DEVELOPMENT REVIEW BOARD – SPEED MEMO

**HYDROLOGY DEVELOPMENT SECTION
DEVELOPMENT REVIEW BOARD MEMO**

4. **Project# 1009577**
13DRB-70461 MAJOR – SITE
DEVELOPMENT PLAN FOR
BUILDING PERMIT

NICHOLS/ NAYLOR ARCHITECTS agents for JPET ALBUQUERQUE LLC request the referenced/ above action for Lot(s) E1A1/ E1A2, **LOOP INDUSTRIAL DISTRICT Unit 1**, zoned SU-2/M1 or NC, located on the southwest corner of ALAMENDA BLVD NE and SAN MATEO BLVD NE containing approximately 6.2033 acre(s). (C-17) [Deferred from 3/27/13, 4/3/13]

SHEET NUMBER
AS1

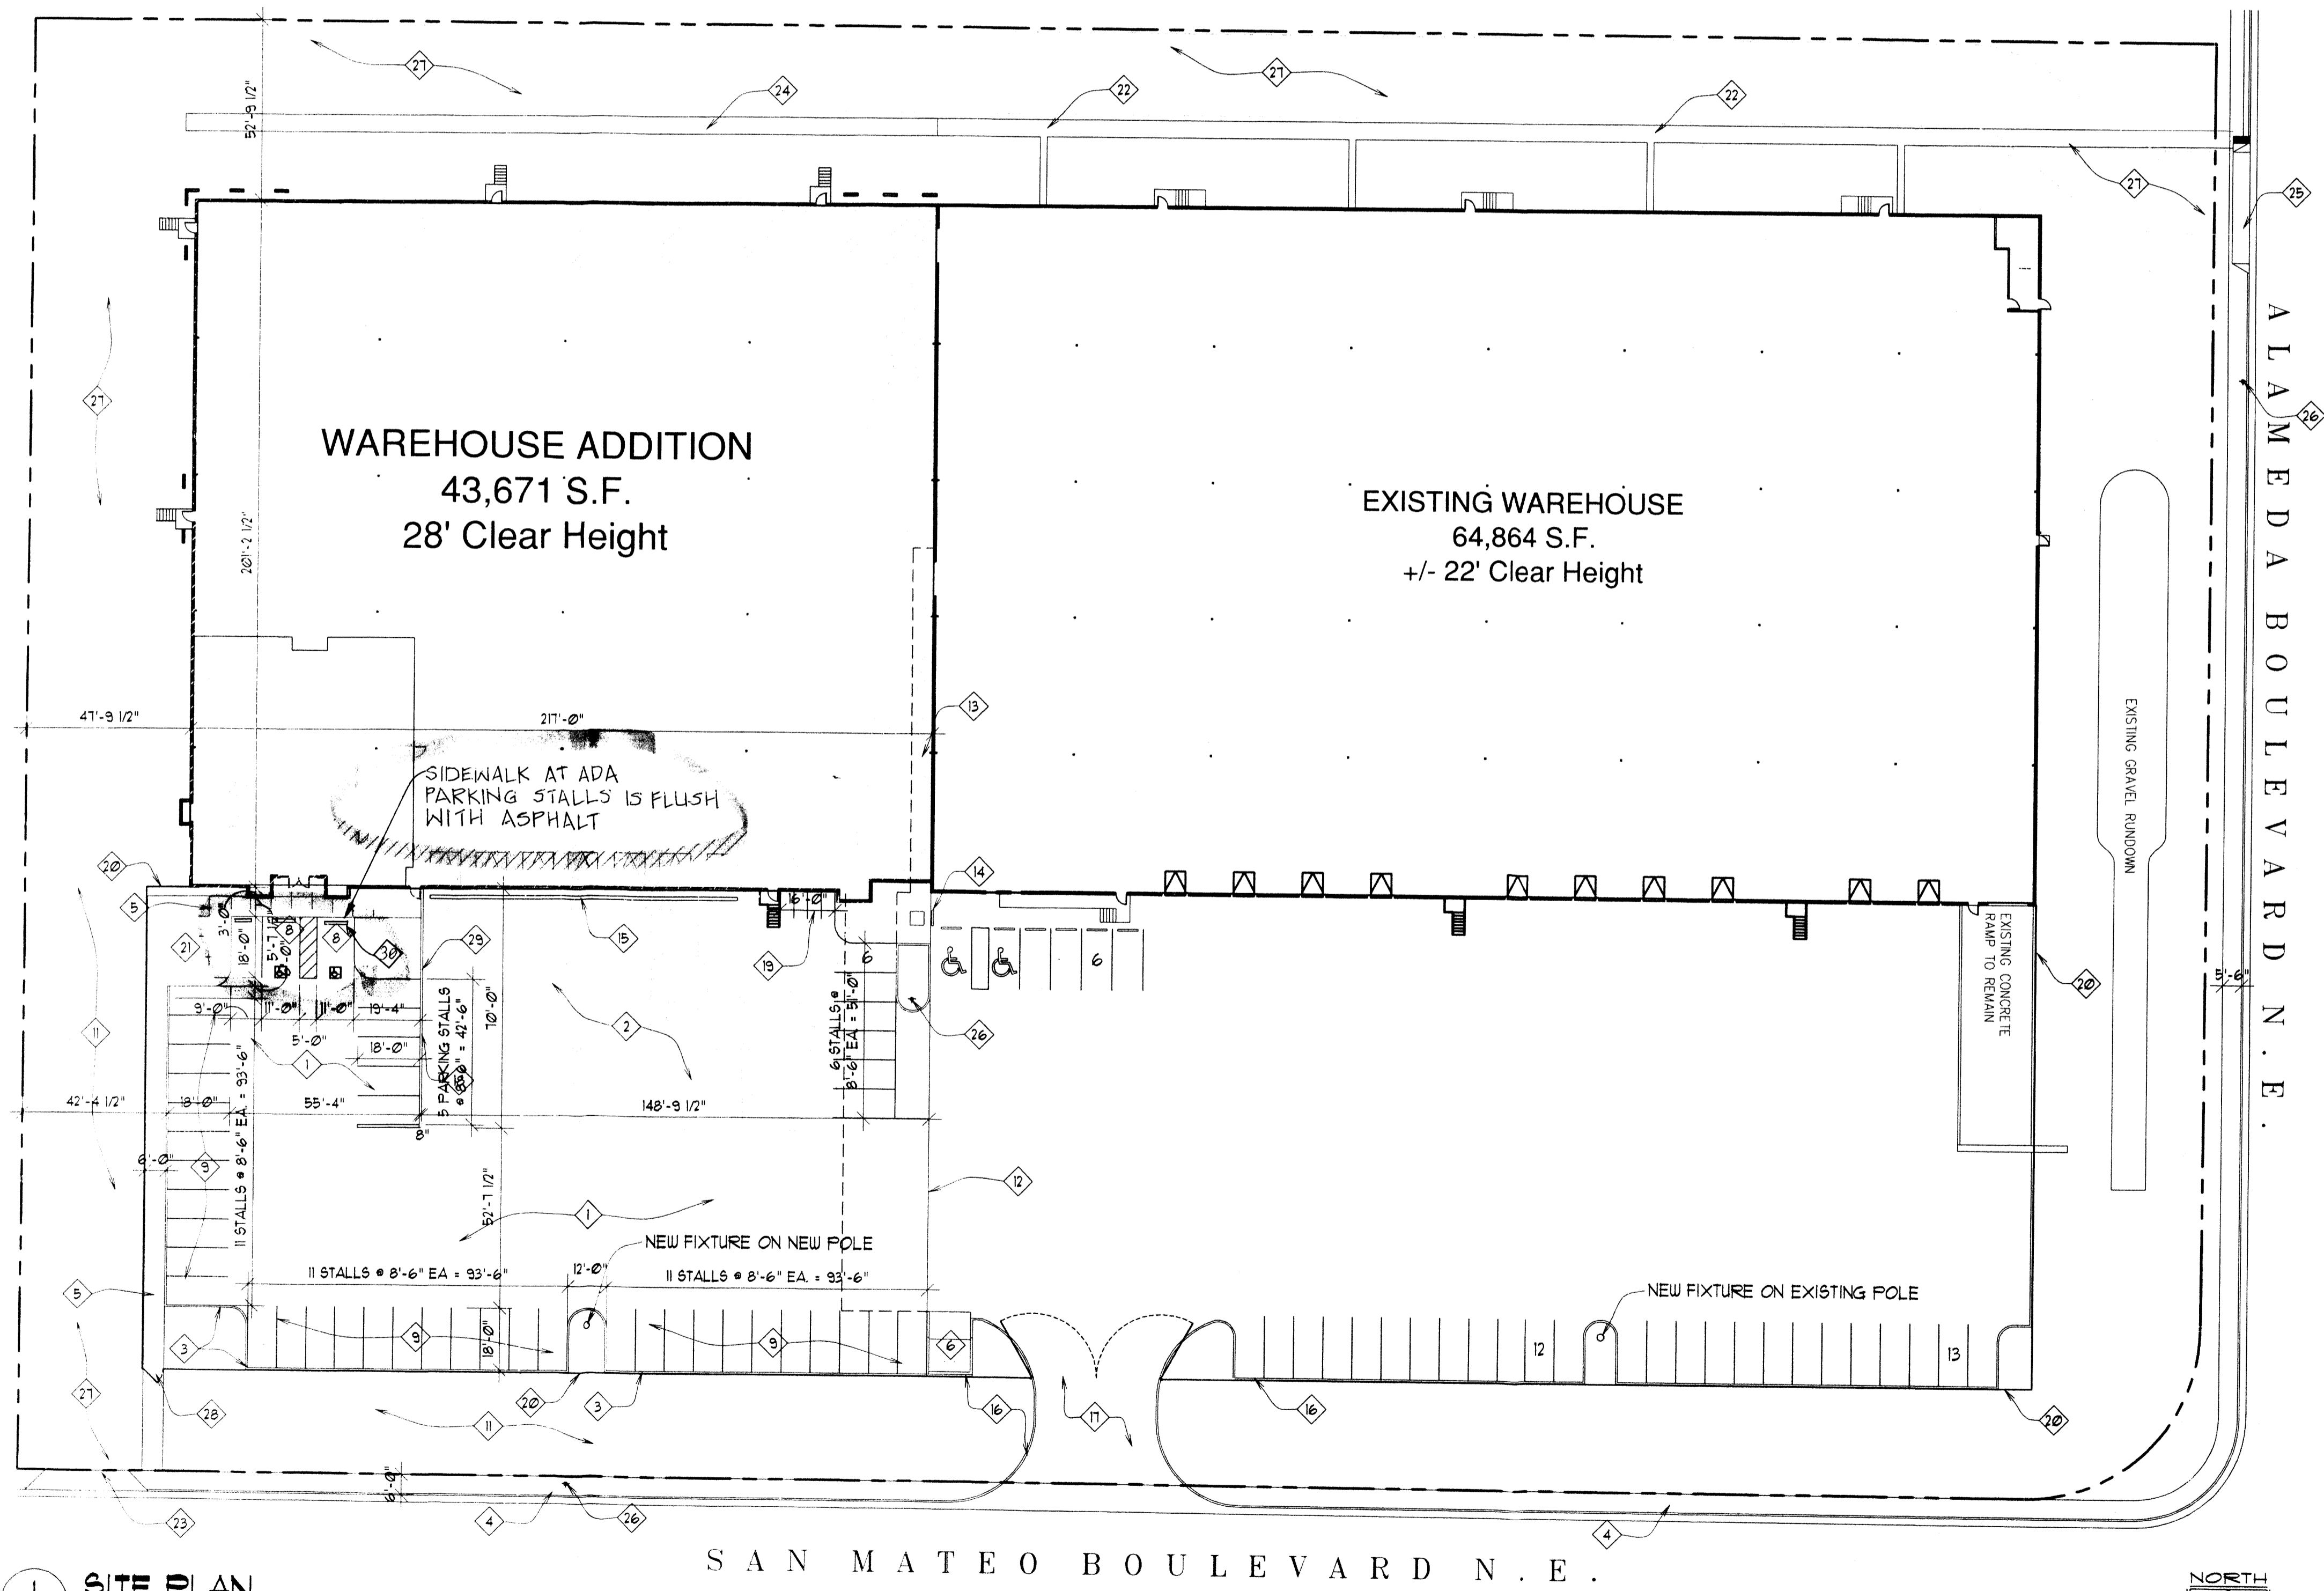
✓ Clearly show the 6-foot wide, ADA accessible, pedestrian pathway from the ADA parking stalls to the building. Show all ramps and provide details. If the sidewalk is flush with the paving in this area, concrete bumpers will be required along this area.

A1 SITE GRADING PLAN
1"=30'-0"

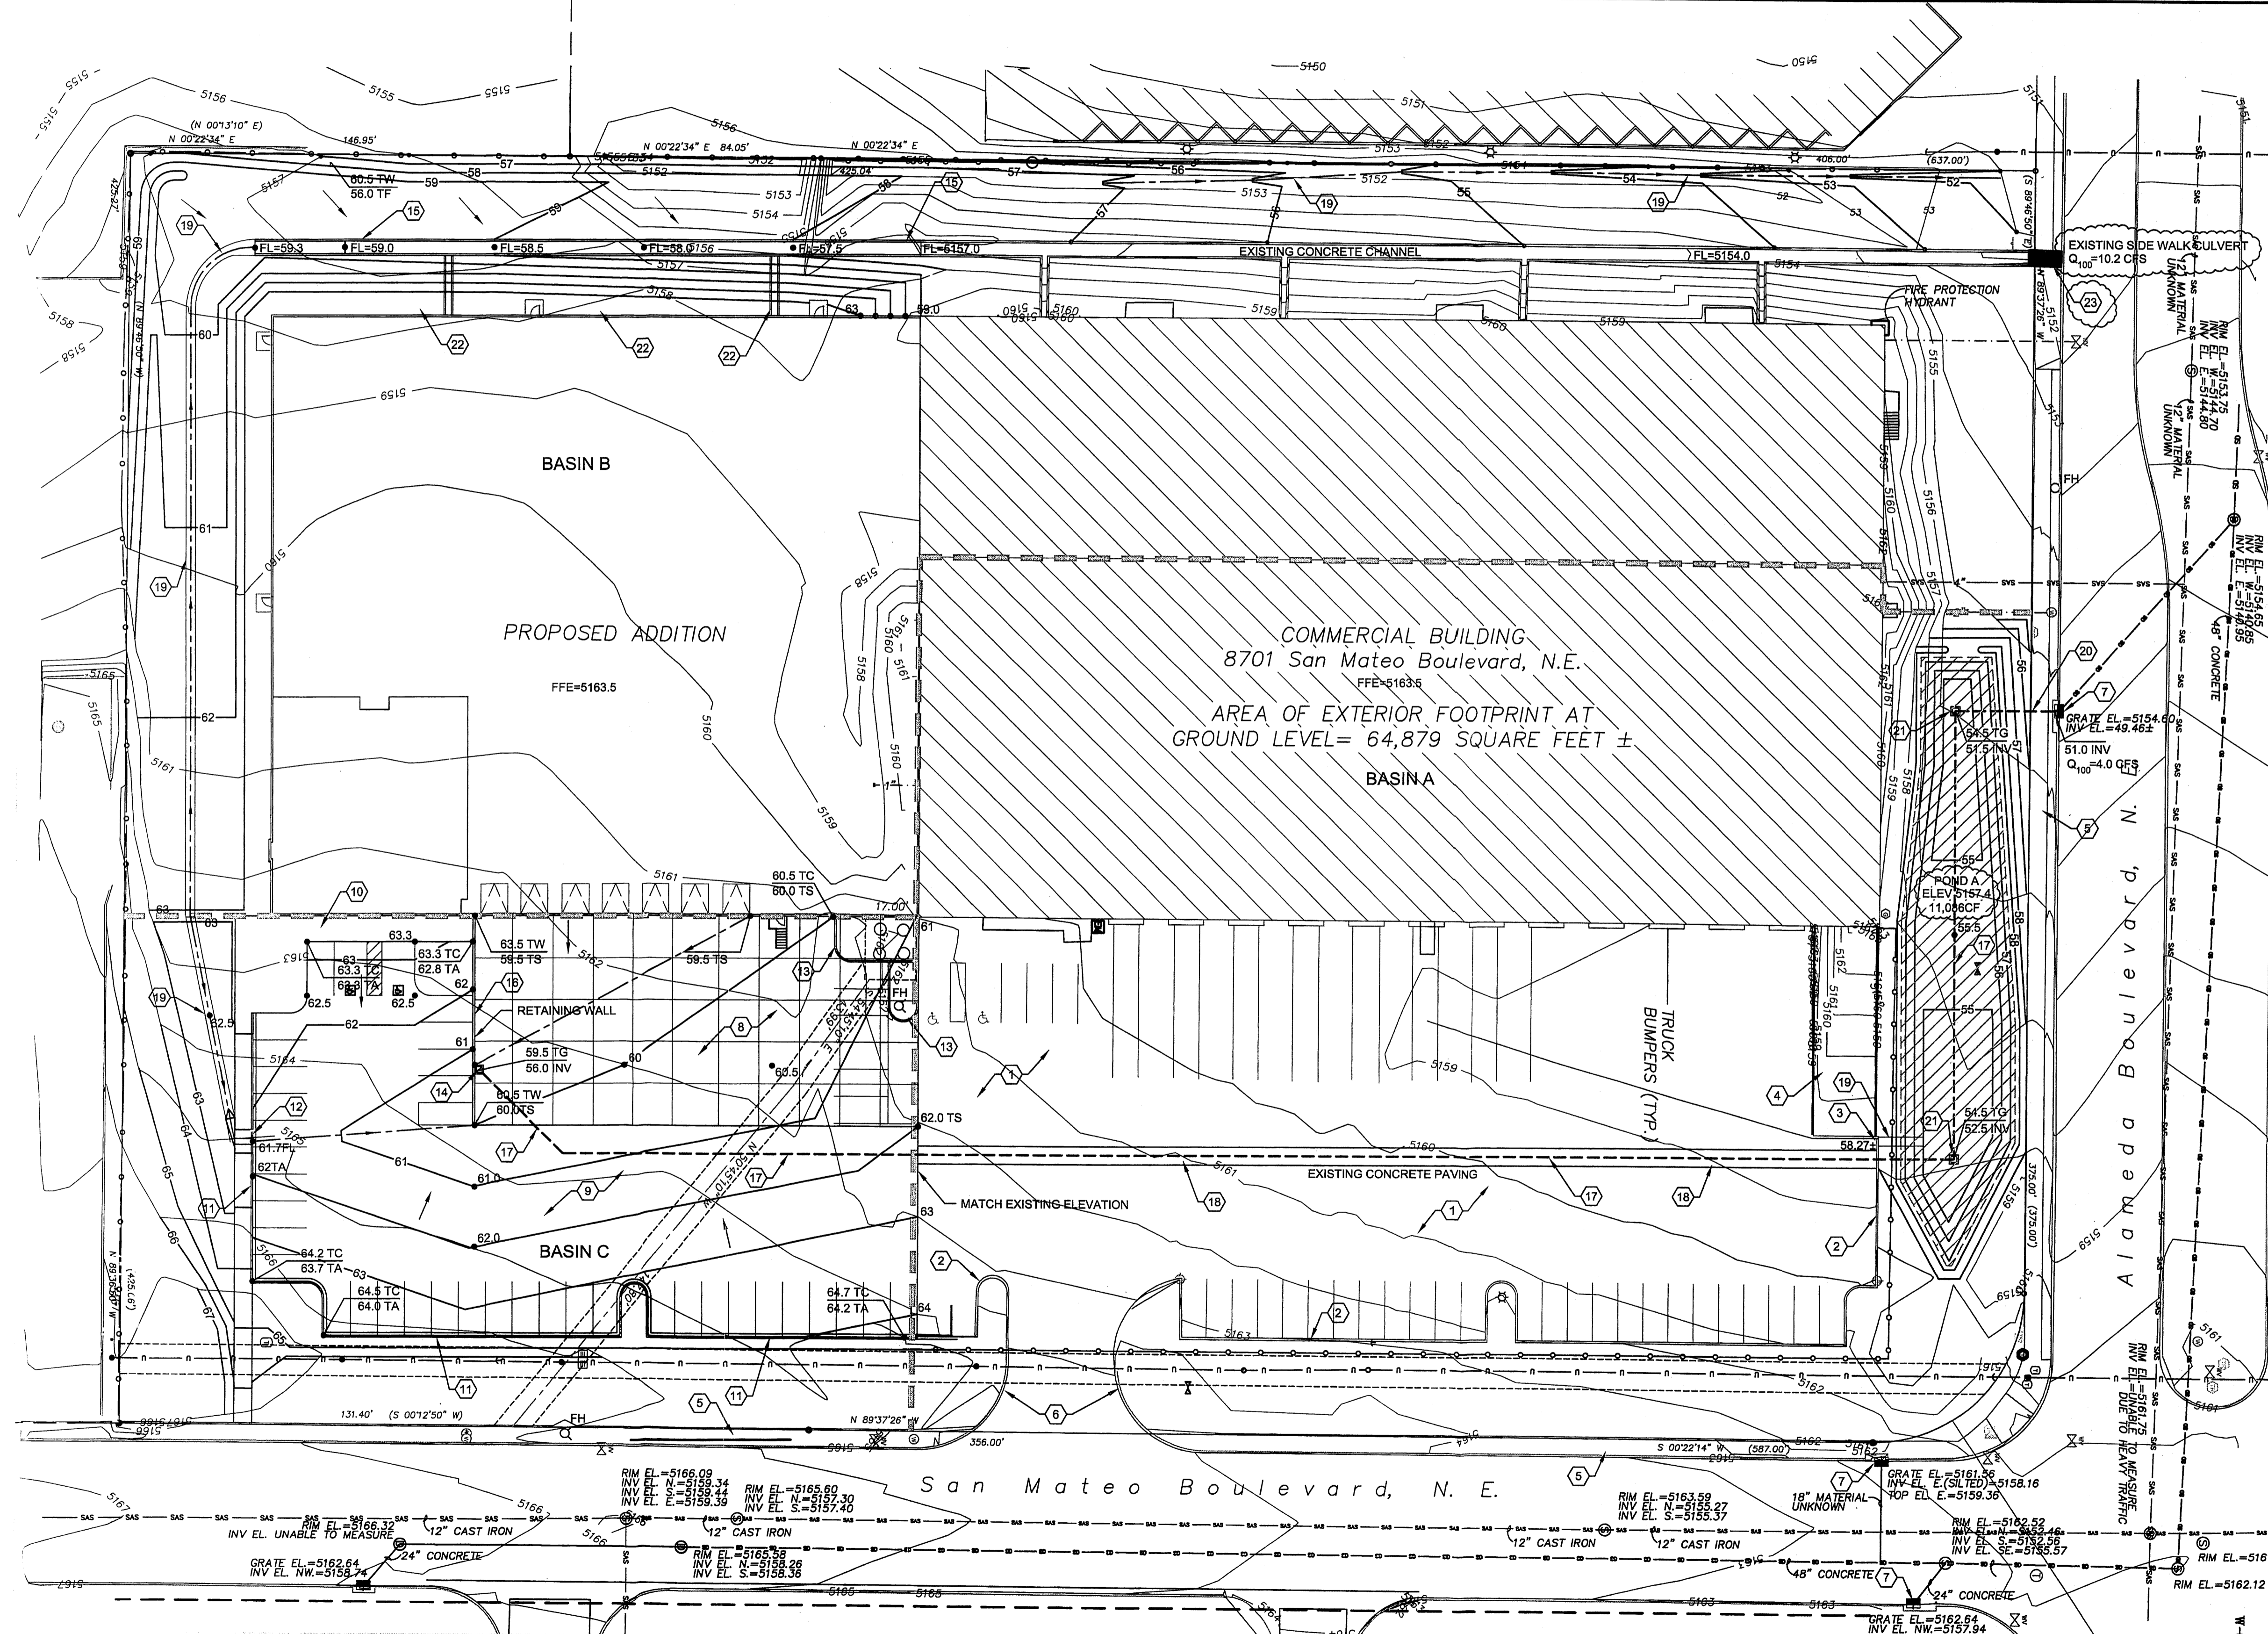
Hydrology has no objection to the Site Plan with the condition that the grades west of the building are addressed at Building Permit.

Include a copy of the approved grading and drainage plan with engineering stamp date 3/27/2013.

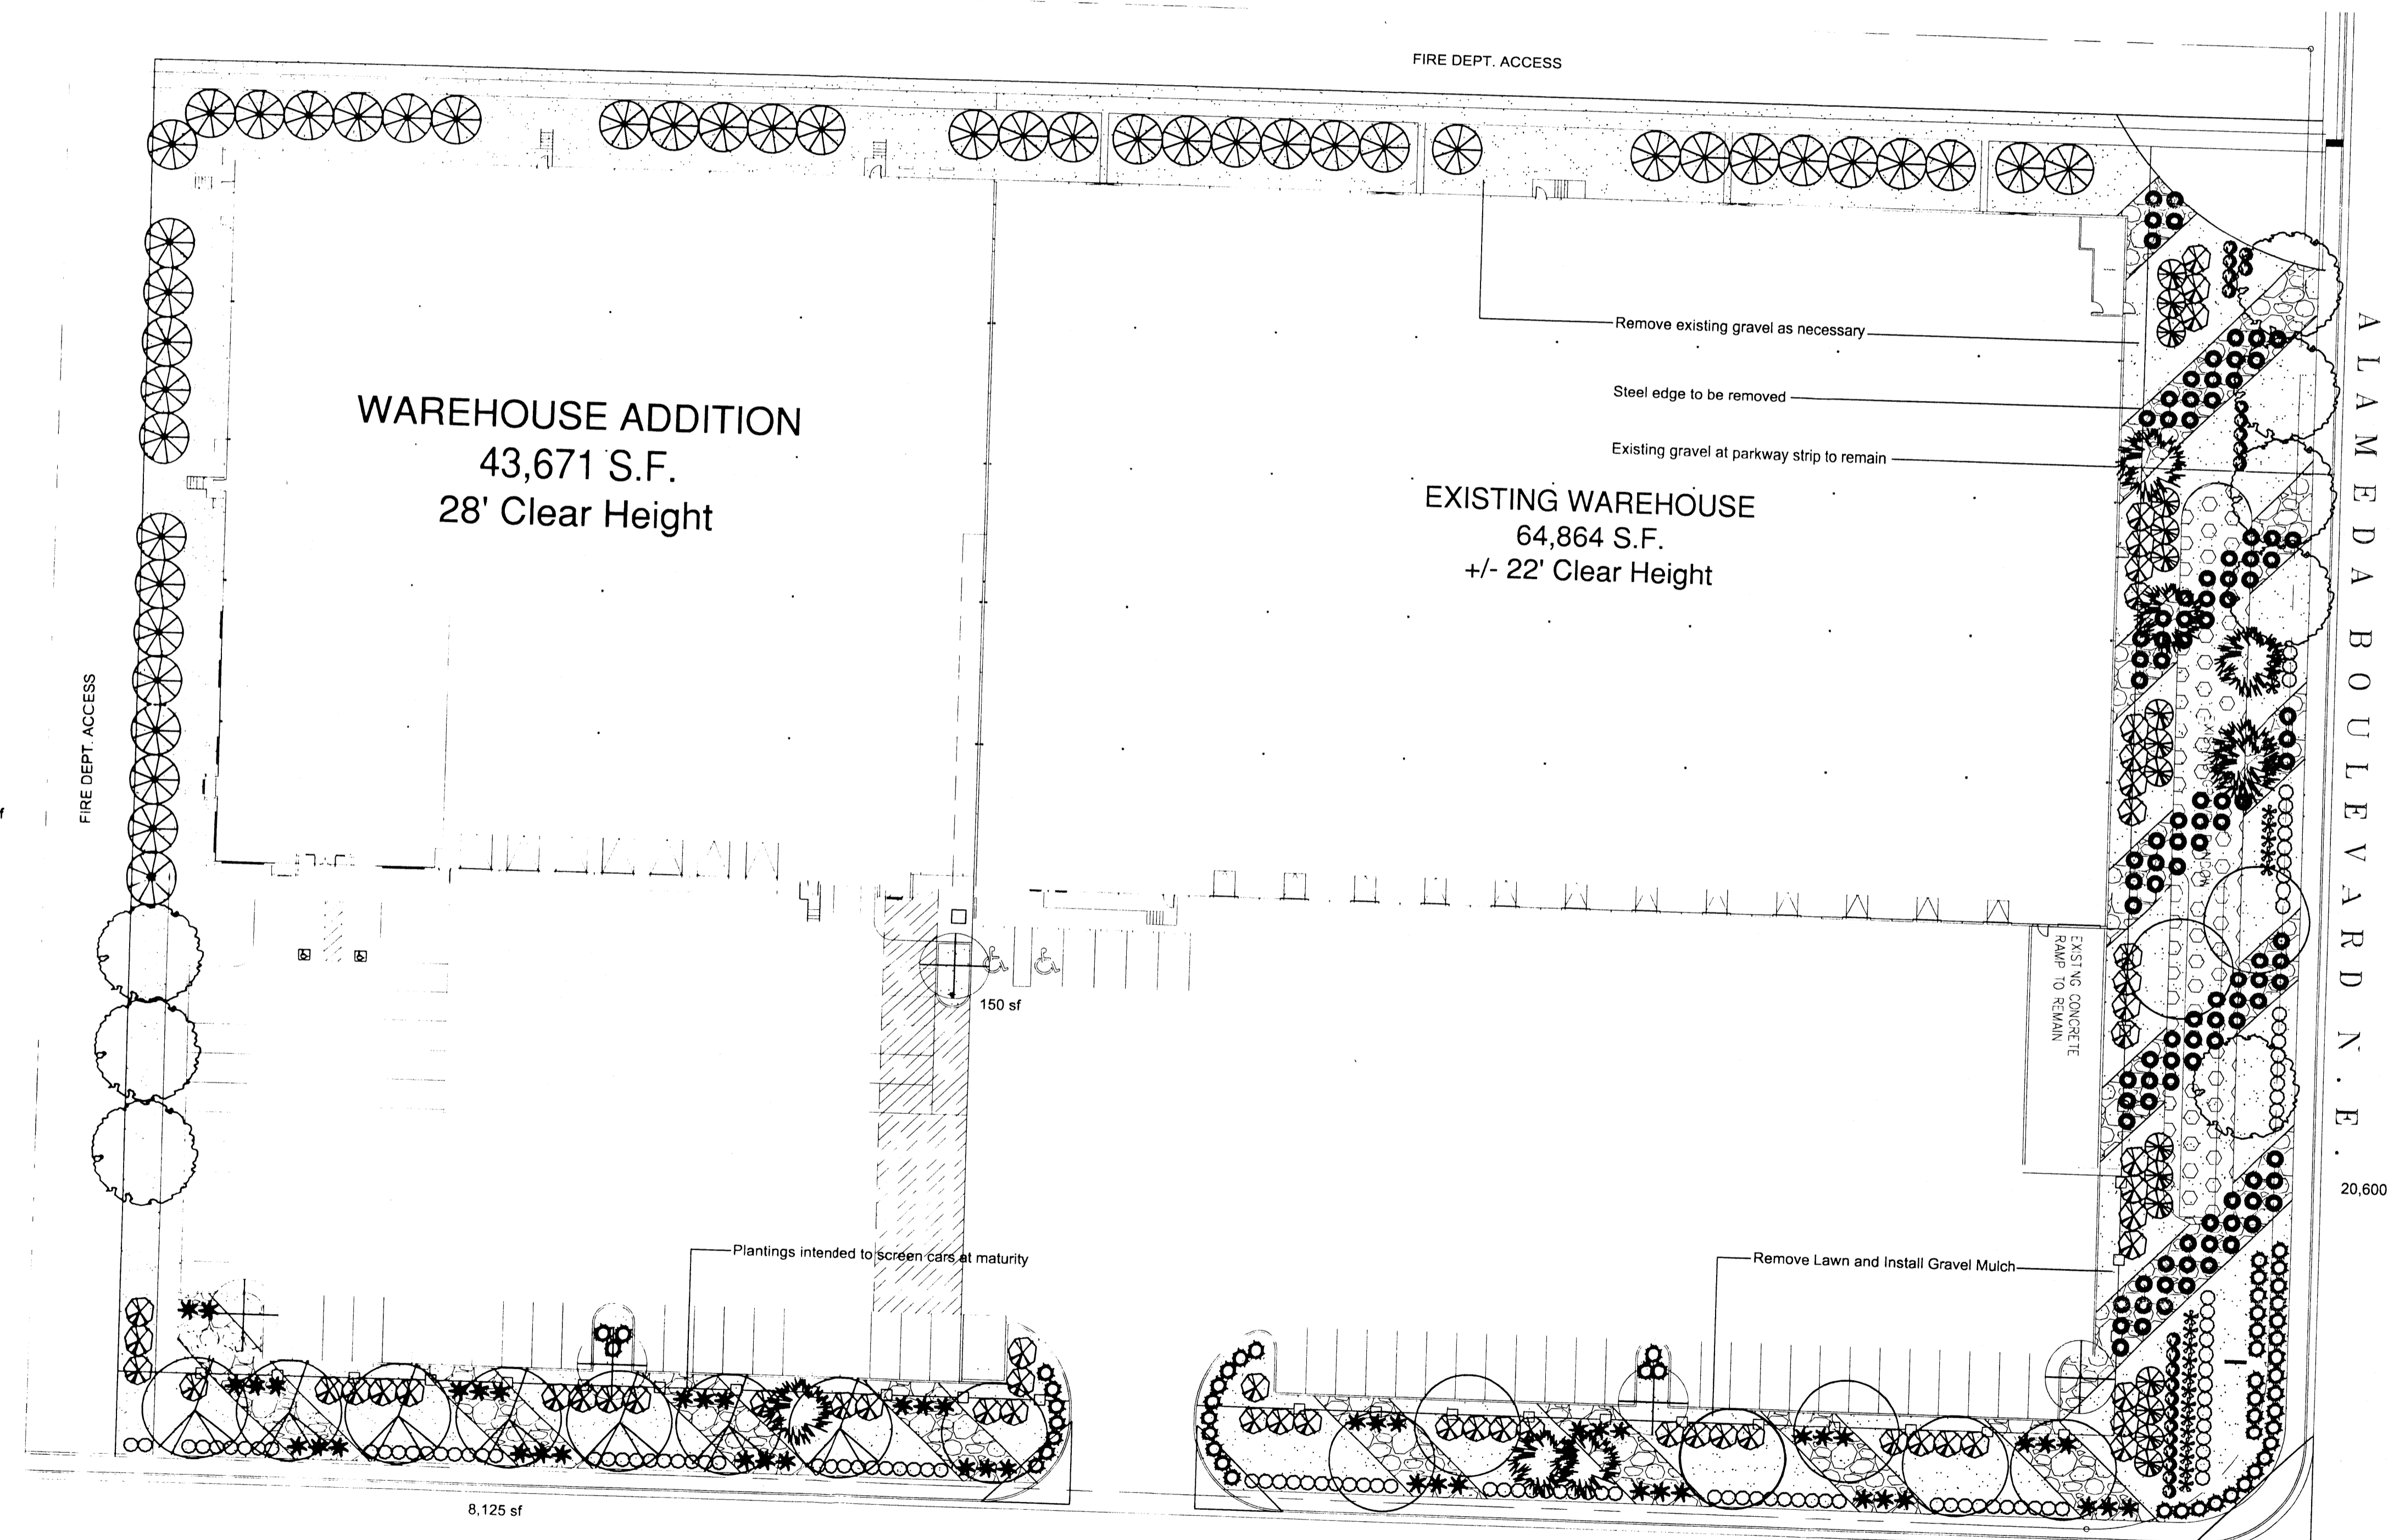
Demonstrate that the signs and landscaping do not interfere with the sight distance of the entrances. Please add the following note to the Landscaping Plan: "Landscaping and signing will not interfere with clear sight requirements. Therefore, signs, walls, trees, and shrubbery between 3 and 8 feet tall (as measured from the gutter pan) will not be acceptable in this area."
